HUNTER VALLEY OPERATIONS

9 December 2022

Hunter Valley Operations MP 06_0261 Modification 8 AN Storage Response to Submissions

Figure 3-2: Additional 7,250 t Storage Area (Ref. [8])

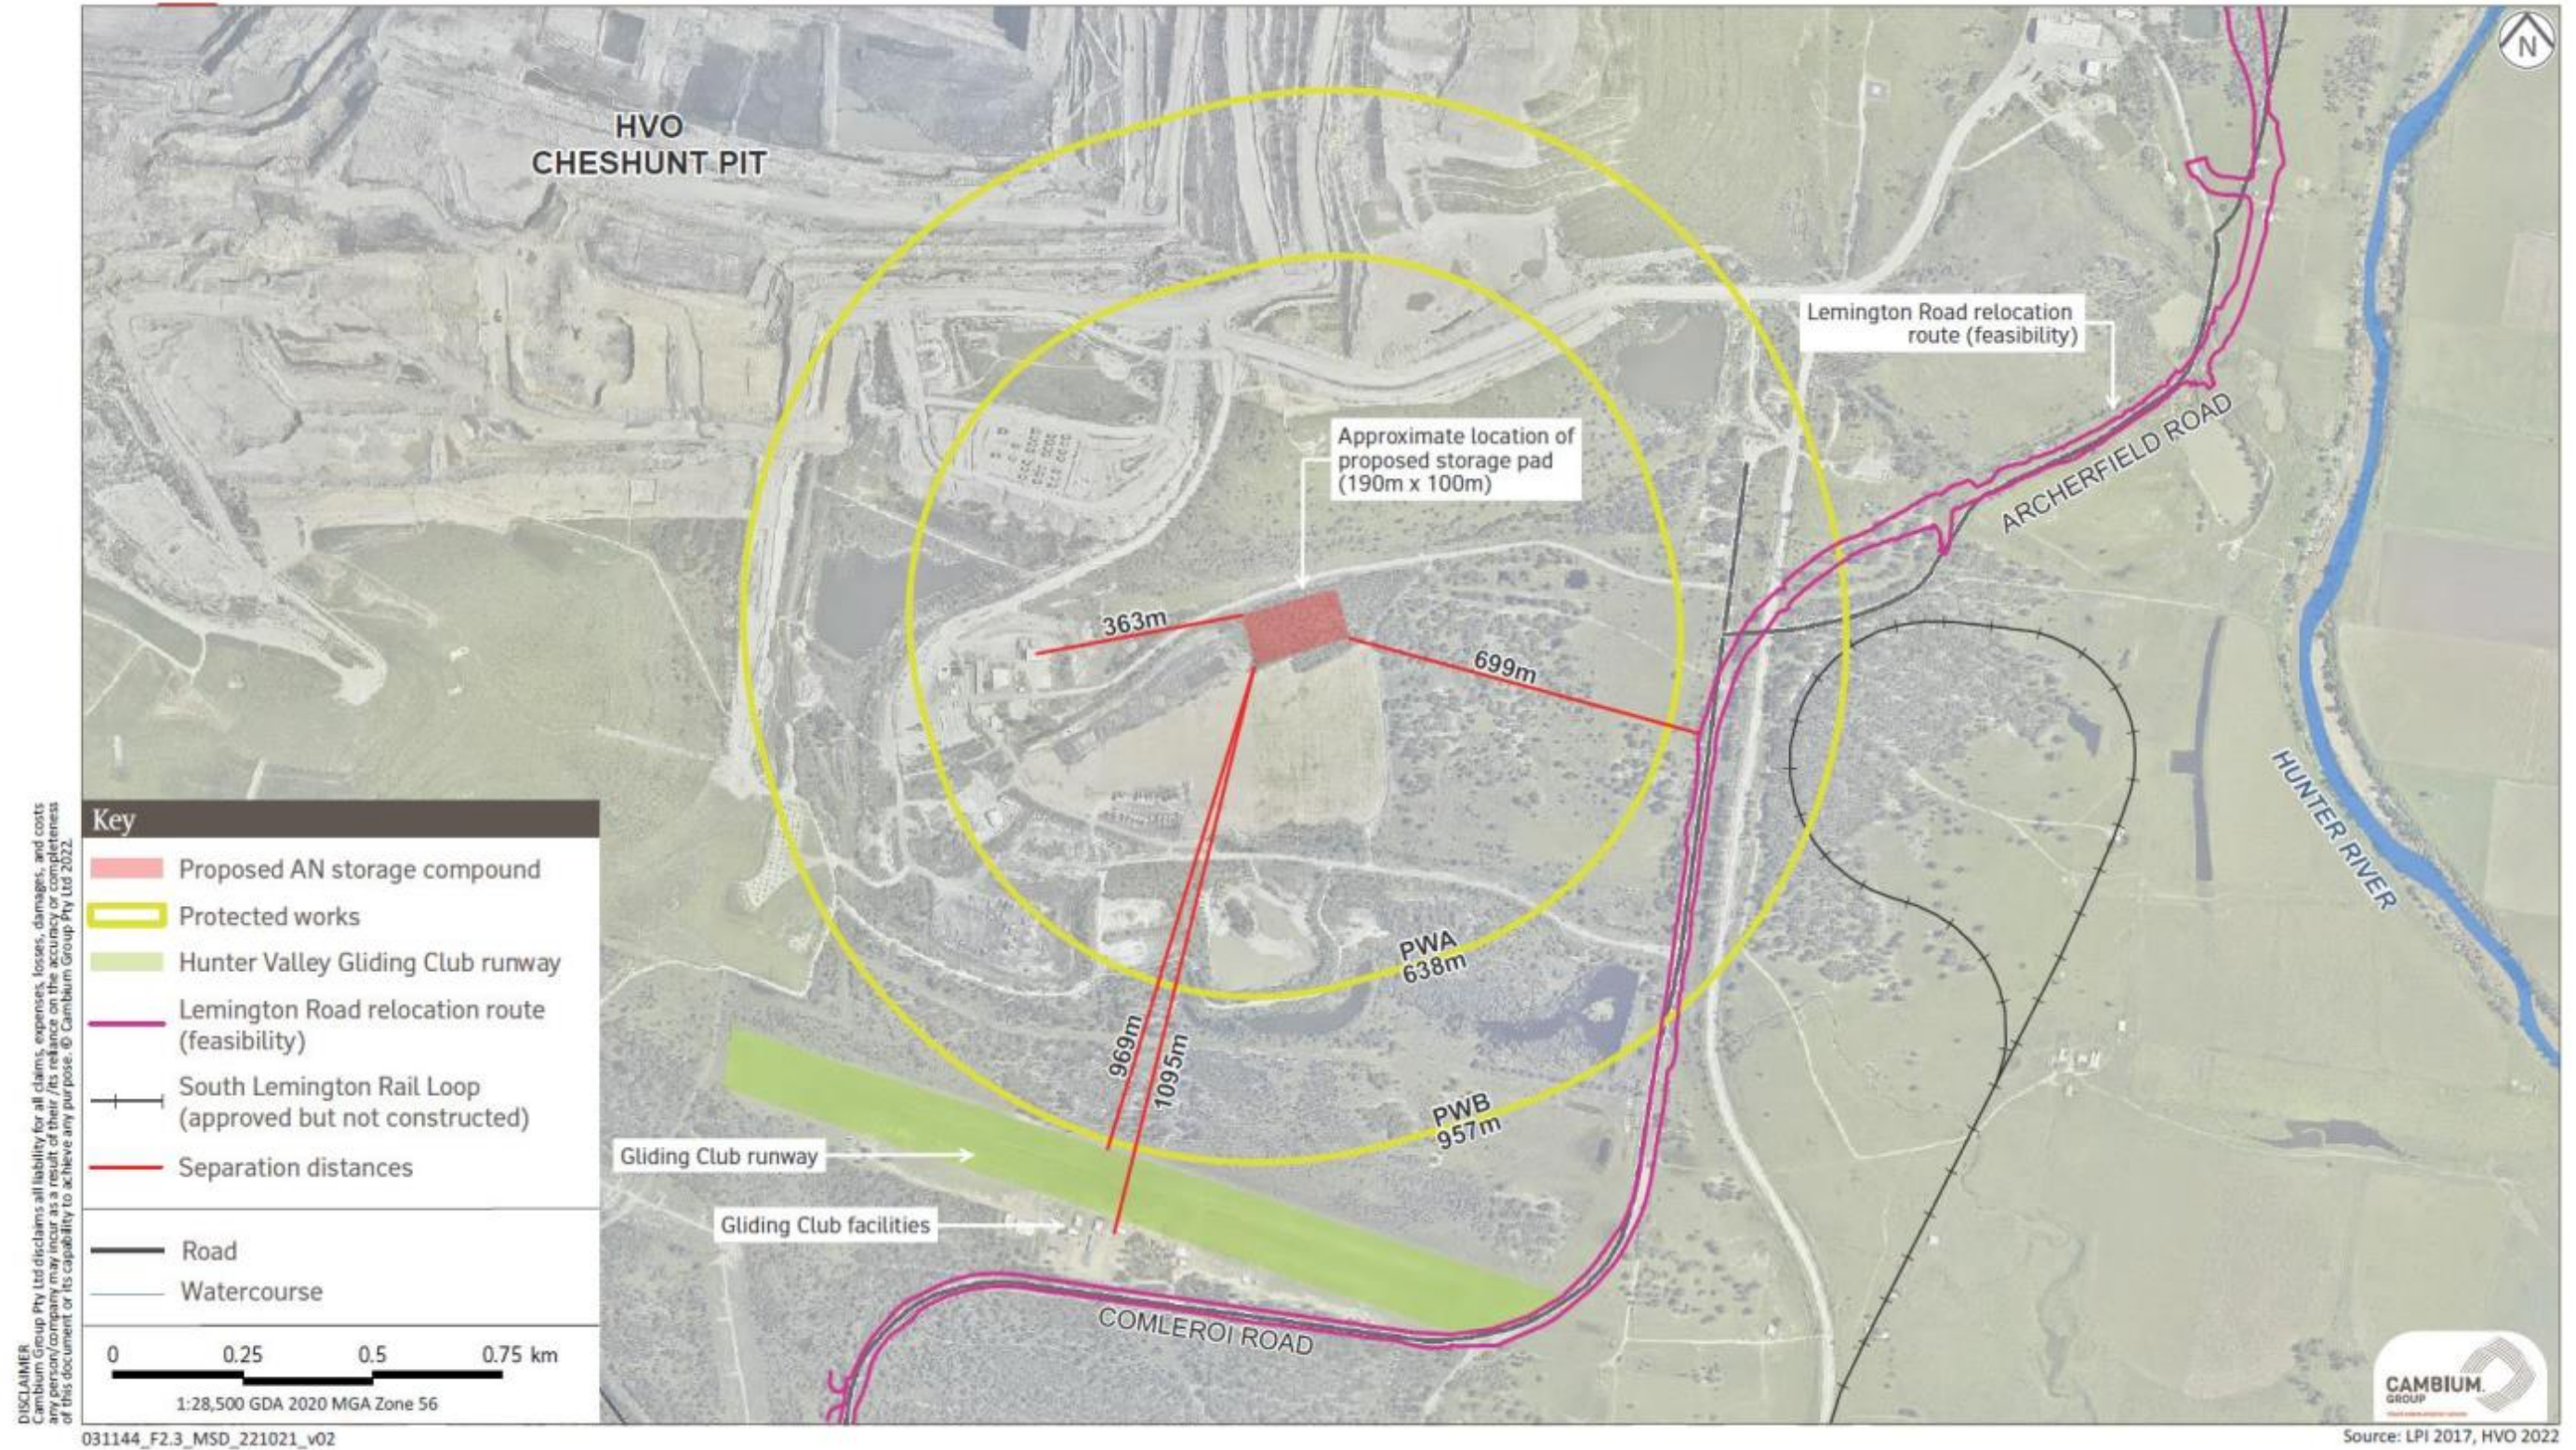
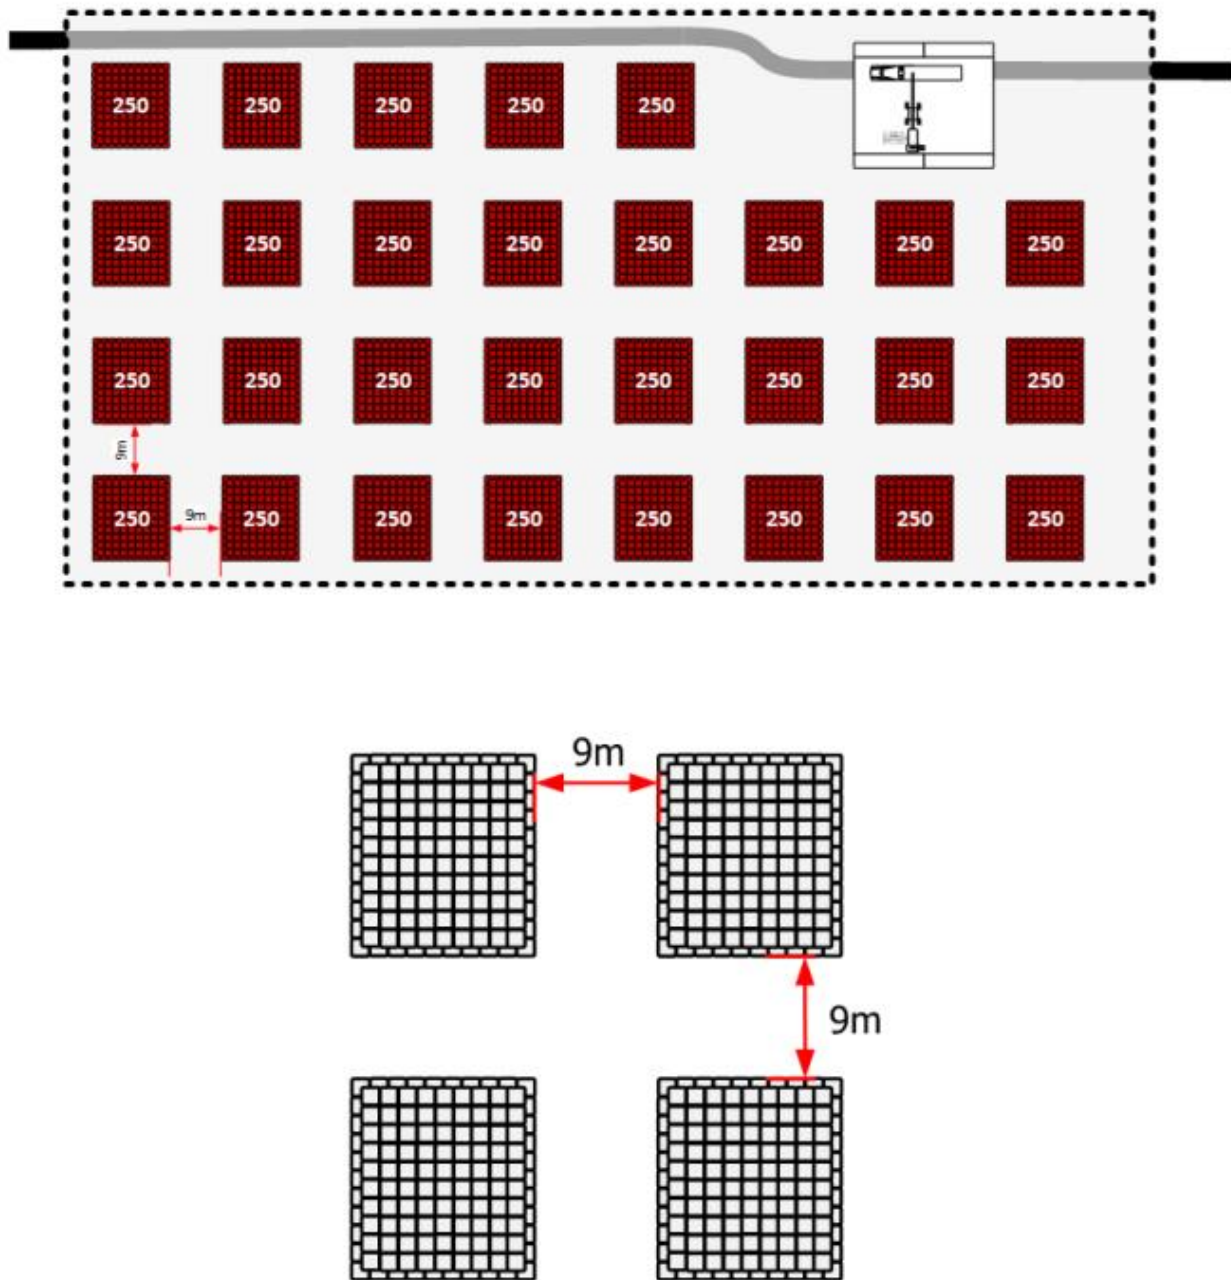
To prevent contamination of soil, surface water and groundwater from the storage and handling of AN, the EPA stated that undercover storage reduces the potential for rain to interact with the AN, and storage under tarps increases the likelihood of spills. In addition, the EPA recommended the following conditions:

1. All Ammonium Nitrate must be stored on an impervious hardstand.
2. All Ammonium Nitrate must be stored under a roofed area.
3. Any runoff from the Ammonium Nitrate storage area must be captured and stored in an appropriately sized containment dam.
4. All storage, handling and manufacturing areas require appropriate containment measures to be installed so that any spills or leakages of Ammonia Nitrate are prevented from being released into the surrounding soil, groundwater, or surface waters.

Further, The EPA also recommends the proponent complies with the requirement of Australian Standard AS 4326 - *the storage and handling of oxidising agents*.

The storage facility has been designed to mitigate potential for contamination to soil, surface and ground water. This can be achieved without the need for a roofed enclosure.

The proposed stack is to be located within a previously disturbed area of the mine and within the mine water management system. As outlined in Table 5.2 of the Modification Report, drainage from the storage area would report to a mine water dam that can accept the run-off generated by a 1 in 10-year, 24 hour period storm event without overflowing. Water levels within the dams across HVO are managed such that water levels are drawn down and sufficient freeboard is maintained when storms are predicted.

The proposed AN storage area will be shaped to manage drainage and restrict ingress into the covered AN bags. The earth pads under the AN bags will be raised and will have an impervious liner on the compacted hard stand directly under the bag. The sides of the liner are pulled up over the first layer of bags and secured by the placement of the second layer of bags. The top liner is then placed over the entire stack to shed water. Figure 1 provides a visual understanding of the storage process.

A hardstand and roof are not proposed for the AN storage due to safety concerns. Institute of Makers of Explosives Safety Analysis for Risk (IMESA FR) is a quantitative risk assessment (QRA) tool used to calculate risk to personnel from commercial explosives facilities and operations. Modelling of open air AN storages (using the IMESA FR model) demonstrates the lowest risk storage scenario is through the use of open-air earthen storage as it reduces the risk of shrapnel and confinement of the product in the unlikely event of an explosion.

The use of open-air stacks is a permissible activity as per AS 4326 Clause 4.3 (a) Open air enclosures and is currently the primary storage type used at the QLD Government explosive reserve located at Bajool. At that site, there is >100,000t of AN stored using this practice. AS 4326 outlines the requirements for storage, handling, operational safety, emergency planning and fire protection for all Division 5.1 dangerous goods, and provides specific storage requirements for AN. The proposed AN compound has been designed in accordance with Australian Standard AS 4326 as stated in Section 2 and Section 5 of the Modification Report.
